DESIGN INTEGRITY PANEL ENDORSEMENT - 8-10 LEE STREET, HAYMARKET [SSD-10405 - MOD 2 AND MOD 3]

This letter has been prepared on behalf of the Design Integrity Panel for the 8-10 Lee Street Haymarket Architectural Design Competition in relation to proposed modifications to SSD-10405.

It provides endorsement of the design modifications by the Design Integrity Panel (DIP) prior to the lodgement of SSD-10405 Modification 2 and SSD-10405 Modification 3.

Figure 3 Habitat Level 4 floor extension

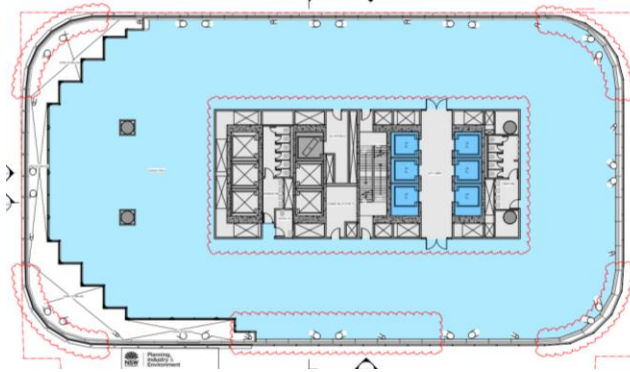
Modification	DIP Feedback
Tower Restack	The Panel support the proposed Tower Restack modifications.
Habitat Level 4 Modifications	<p>The Panel support the proposed modifications to the habitat levels.</p> <p>The reduction in height of the habitat atriums from 4 floors to 3 floors with a full-size intermediate floor is considered acceptable, noting that this addresses fire engineering constraints.</p> <p>Bringing the timber soffit of Level 4 to the façade is supported.</p>
Timber Fire Protection	<p>The Panel accept the proposed modifications relating to timber fire protection noting that this is required to manage fire safety compliance requirements. In accepting this, the Panel were assured that the habitat spaces continue to achieve full exposure of the CLT which is strongly supported.</p> <p>Replacement of timber ceiling soffit finishes require careful consideration to ensure the timber quality of the building is visible and legible both internally and externally per competition scheme intent.</p>

Figure 6 Approved and proposed Crown façade

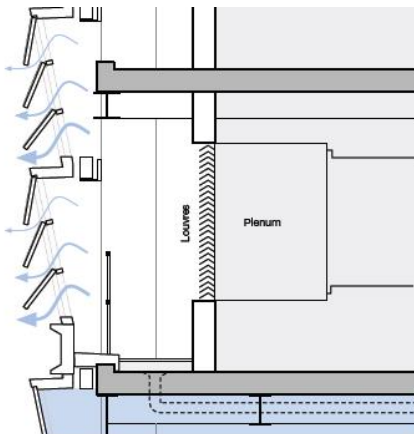
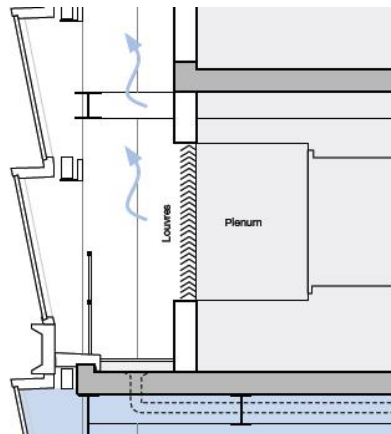
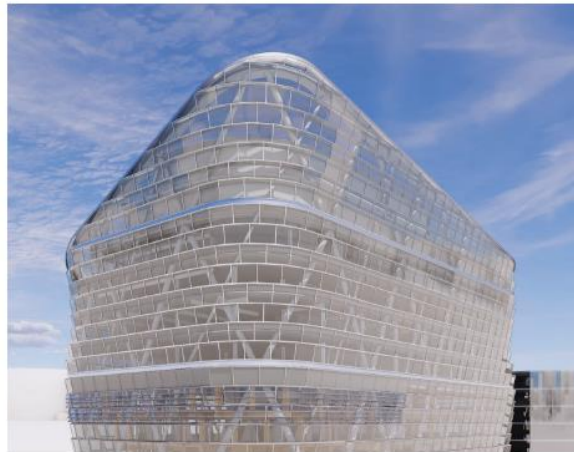
Façade and Crown Modifications	<p>The Panel raise no concerns with the proposed modifications to the façade and the crown as presented.</p> <p>The removal of the external terrace stairs at the crown levels is supported as it allows more greening of the terraces and more useable space.</p>
YHA Internal Planning	The Panel support the proposed YHA internal planning modifications.
